File Ref: SSD-27208140_RTS

25 May 2022

**RE: Response to Submissions
St Aloysius College - Rozelle Campus
Property: 2A-2B Gordon Street & 48 Victoria Road, ROZELLE**

Swept Path Analysis

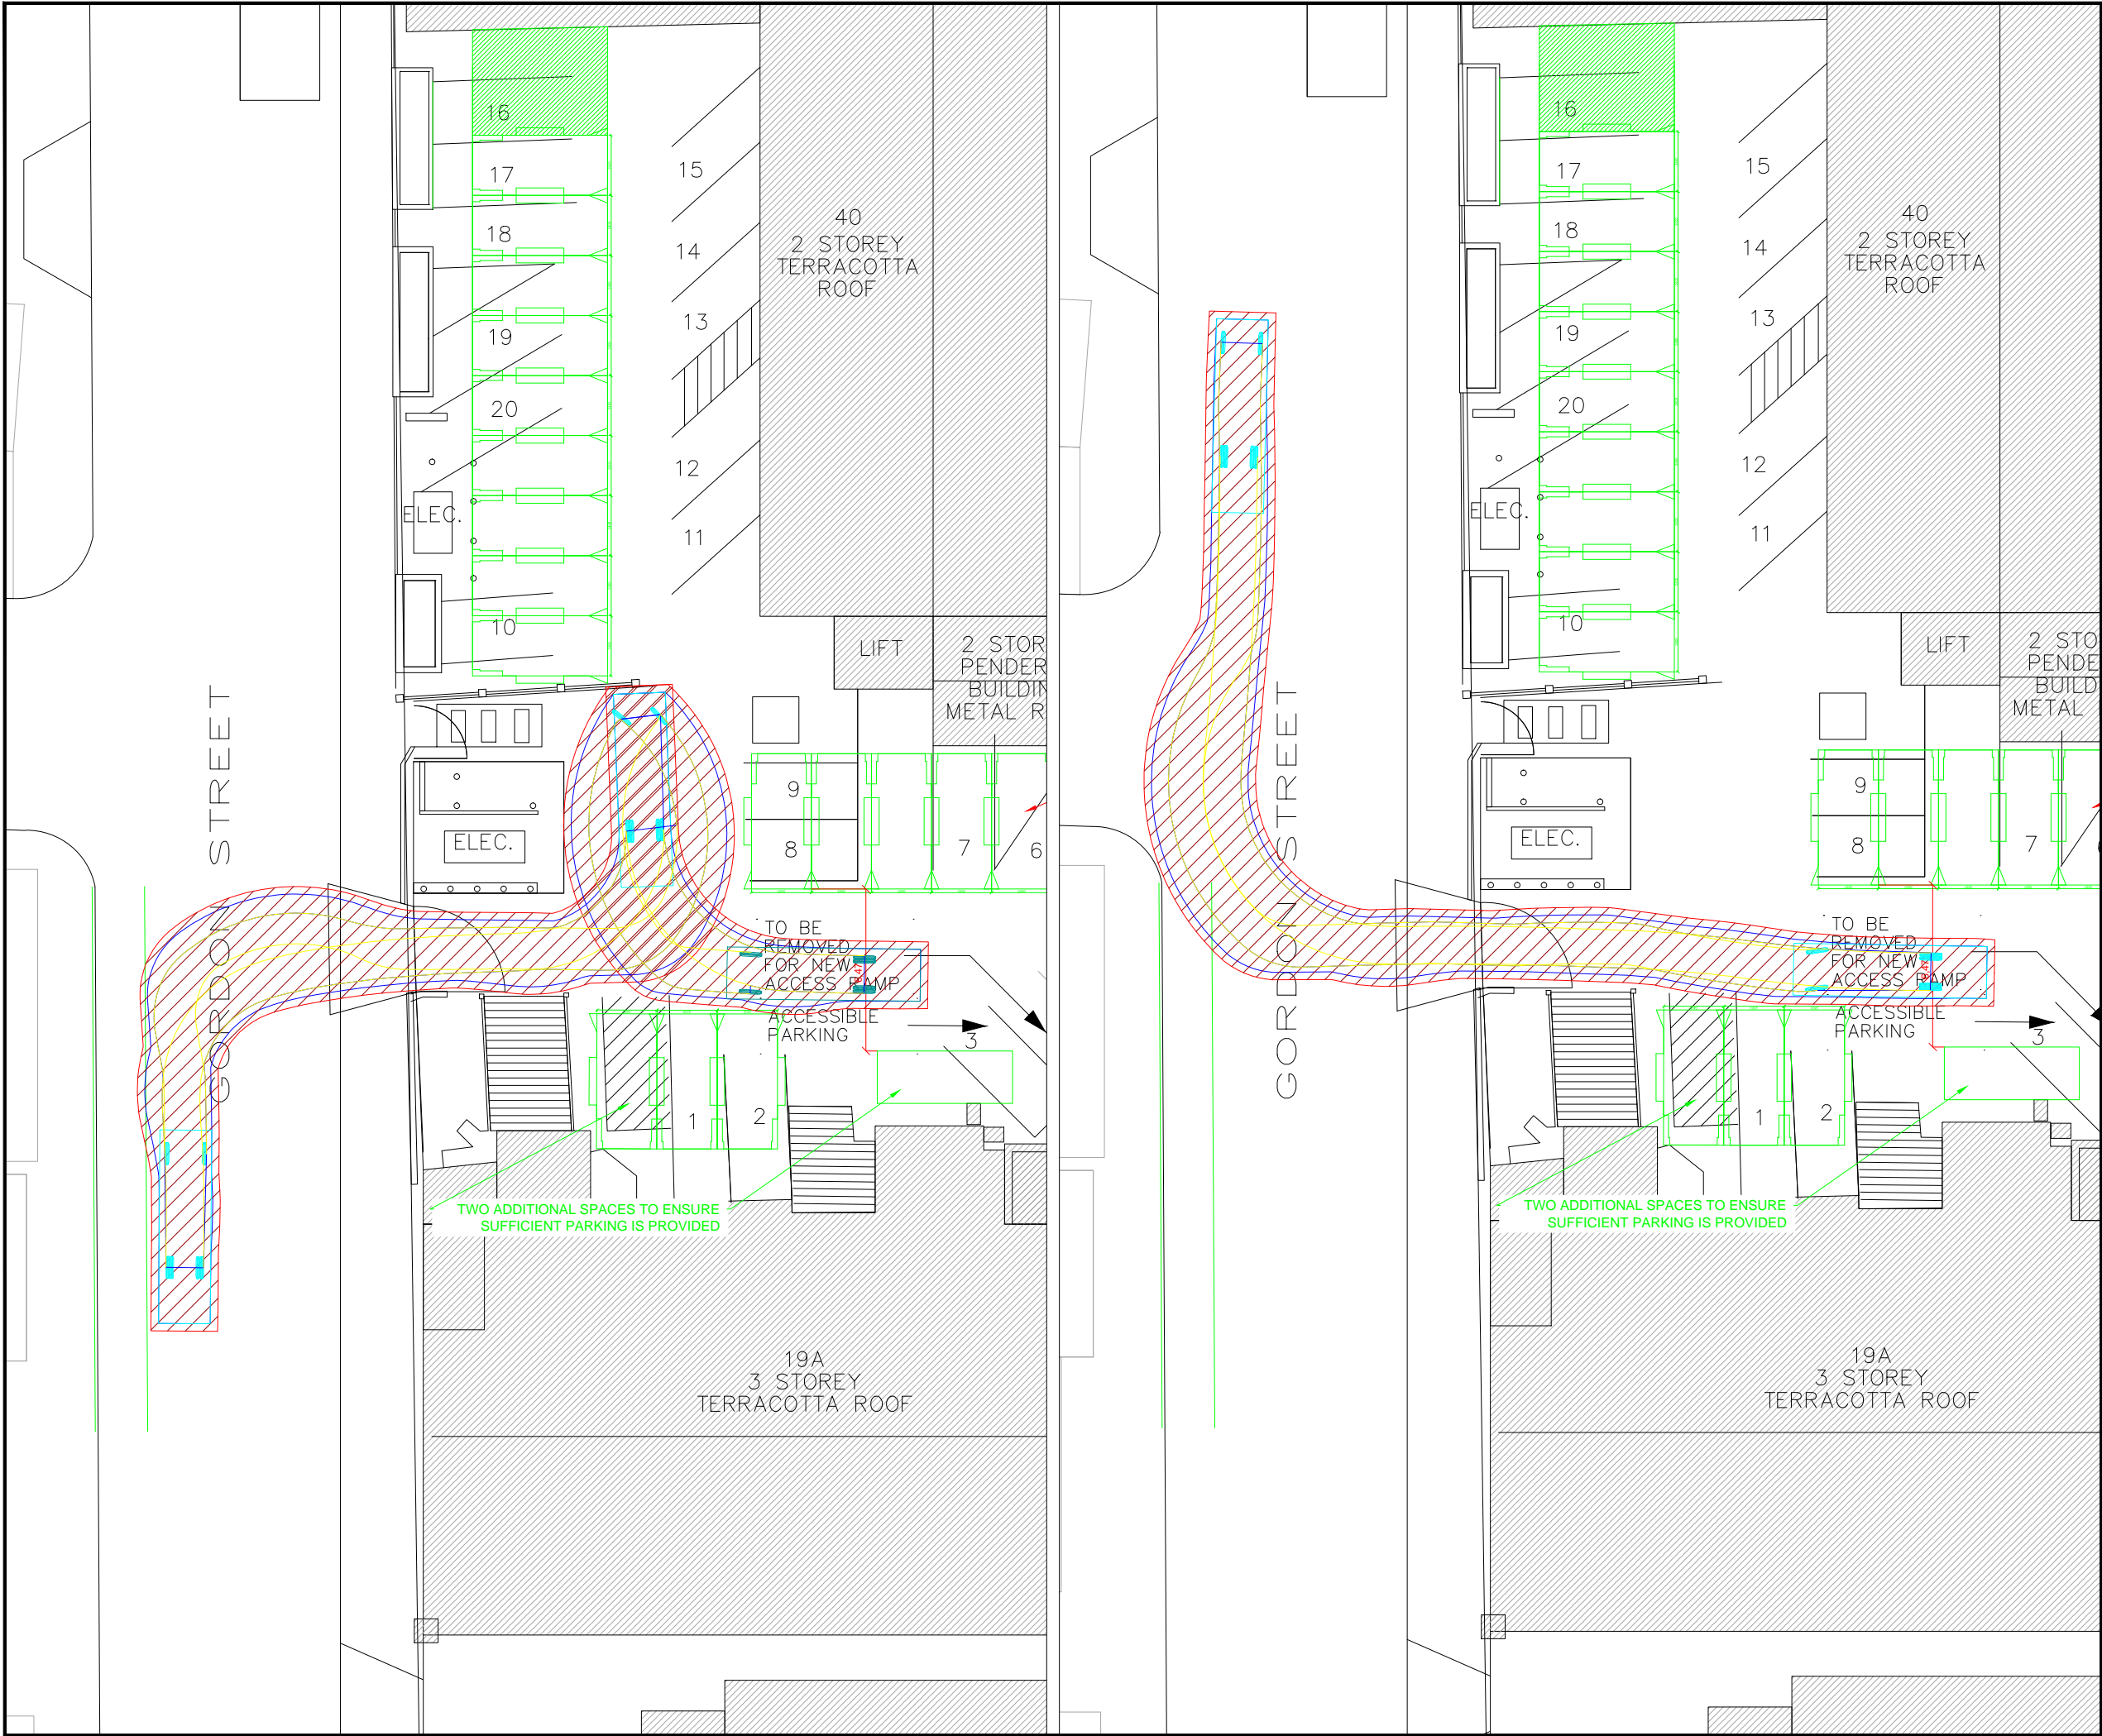
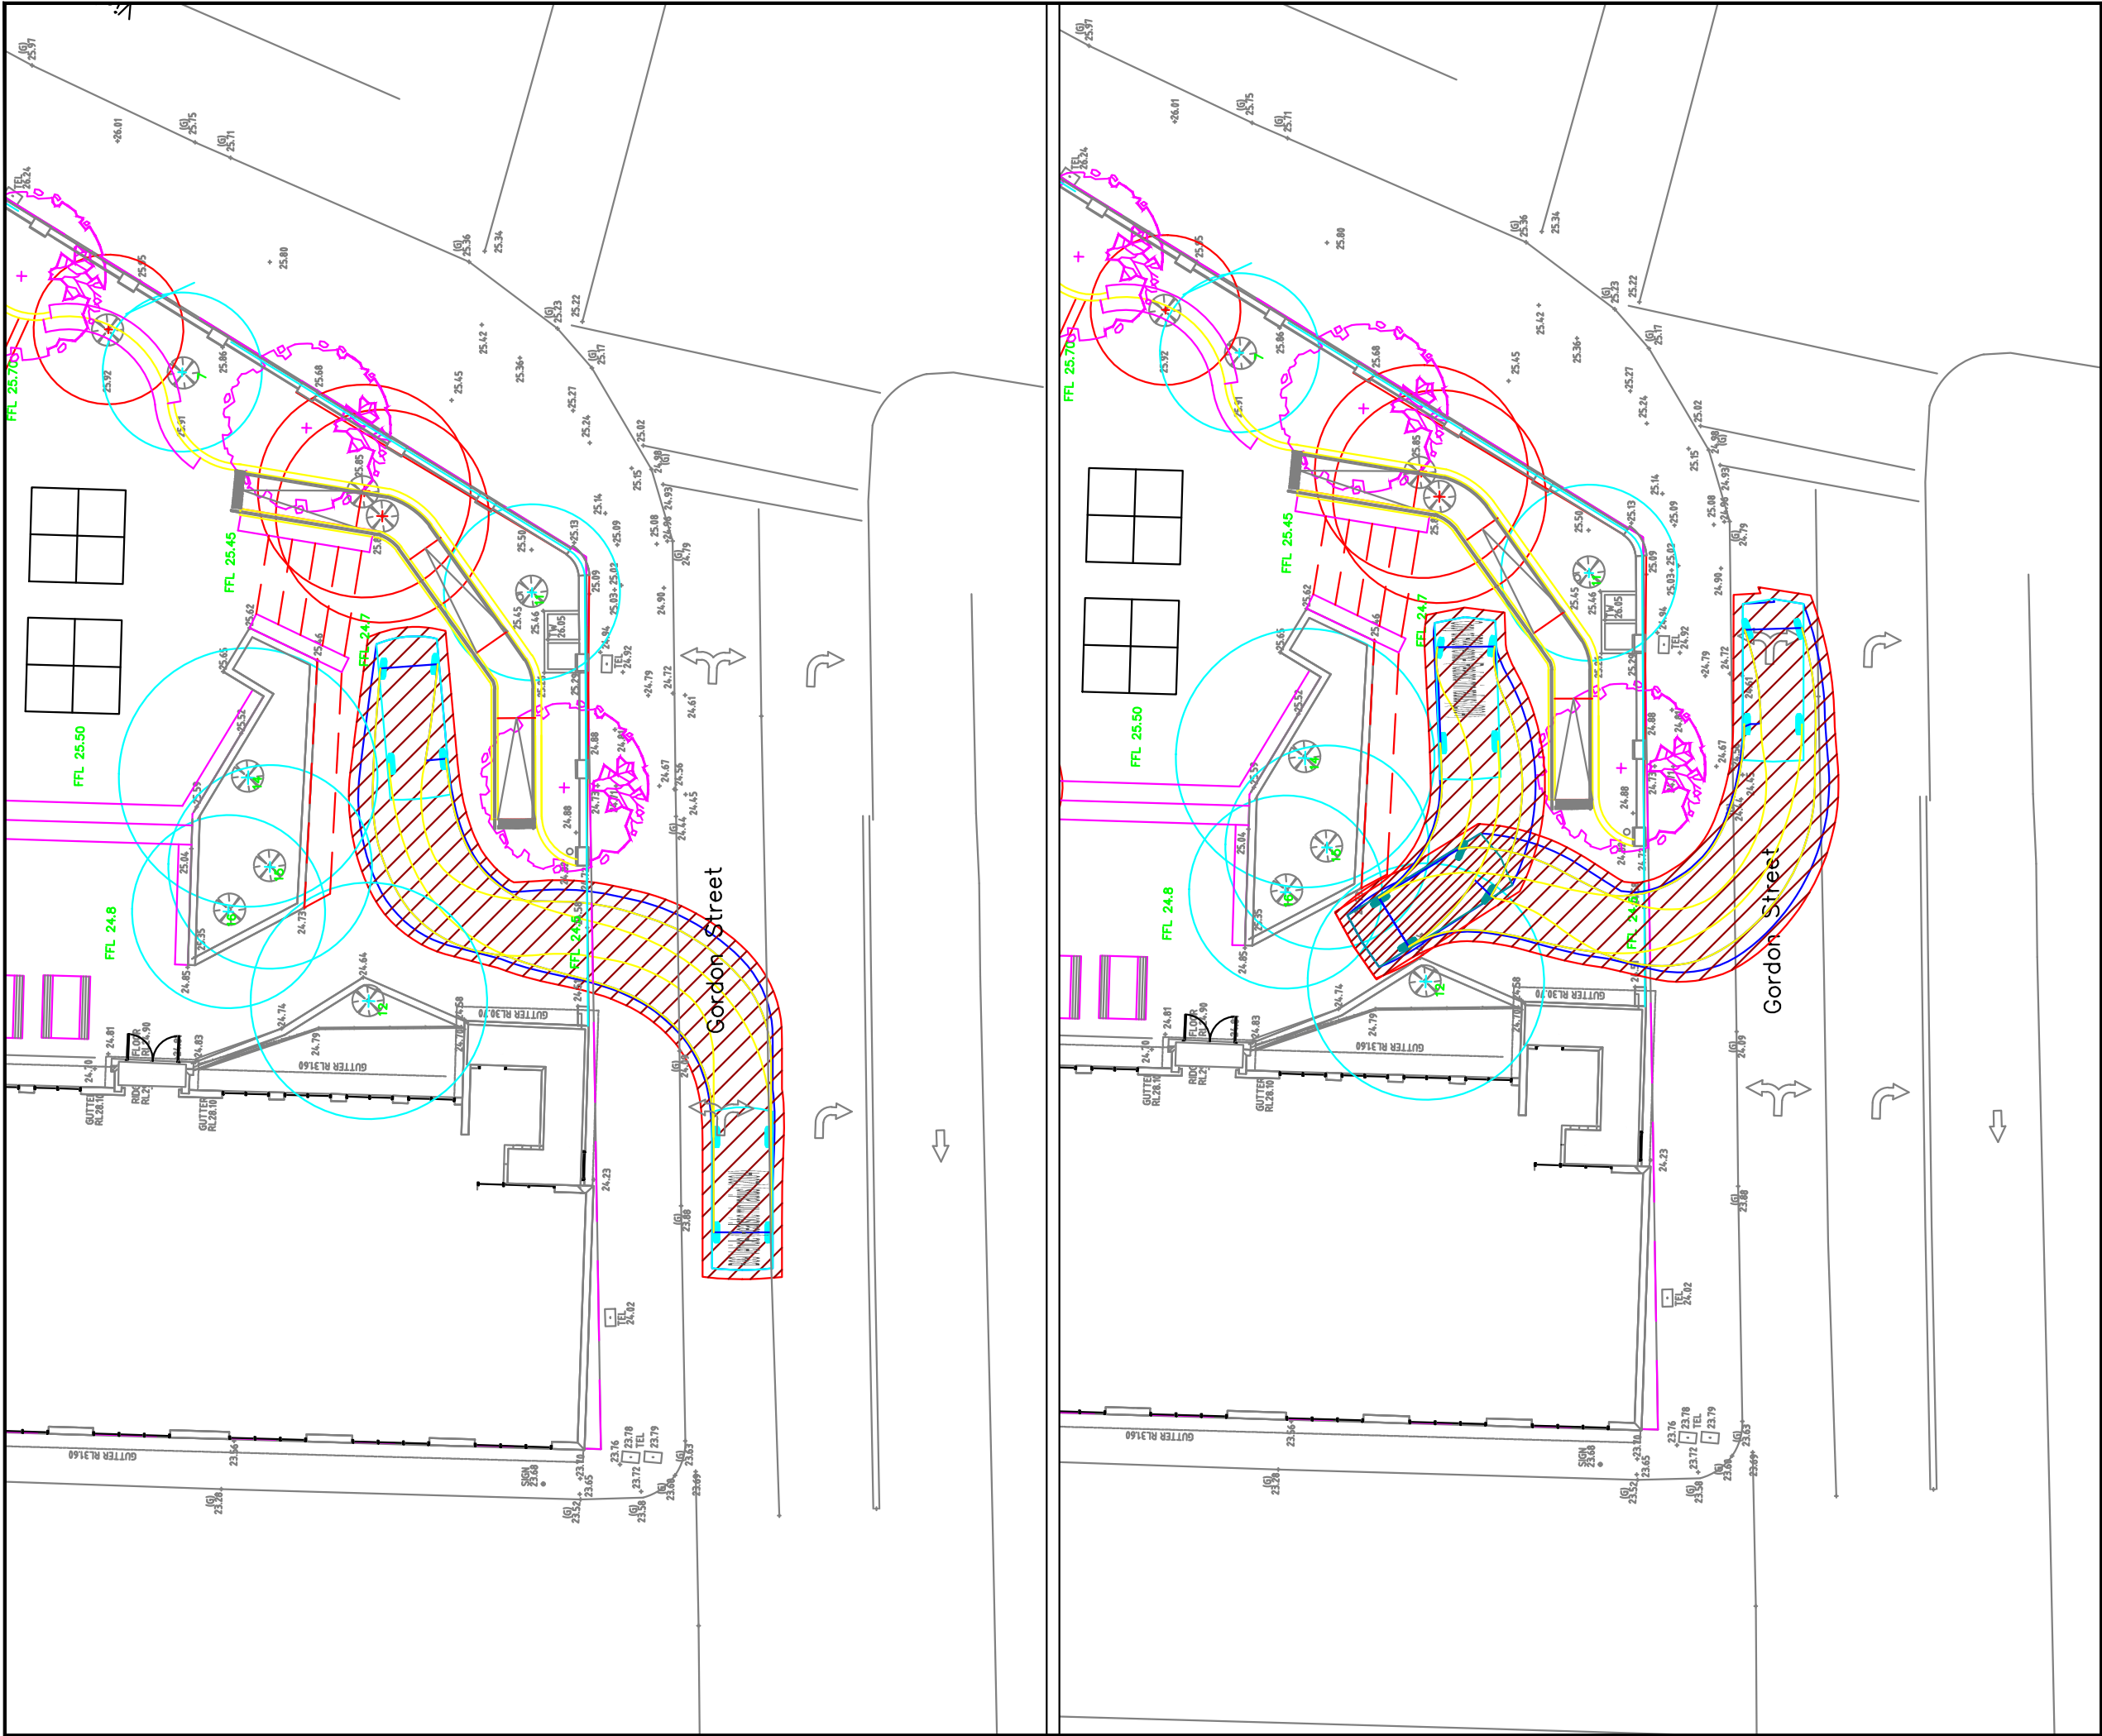
- i. As shown in Figure 1 below, the swept paths show that the manoeuvre is very tight, and the gate encroaches within the 300mm clearance bands either side of the vehicle. Further investigation should be undertaken to explore whether there is scope to widen the entry gates and driveway.

- ii. As shown in Figure 2 below, the swept path also details that the shuttle bus will impact a bollard protecting the electricity substation and drops off the edge of the kerb shown circled in red (Figure 3). Further investigation should be undertaken to explore whether there is scope to set the kerb back and to relocate the bollard to allow for better manoeuvrability of the shuttle bus.
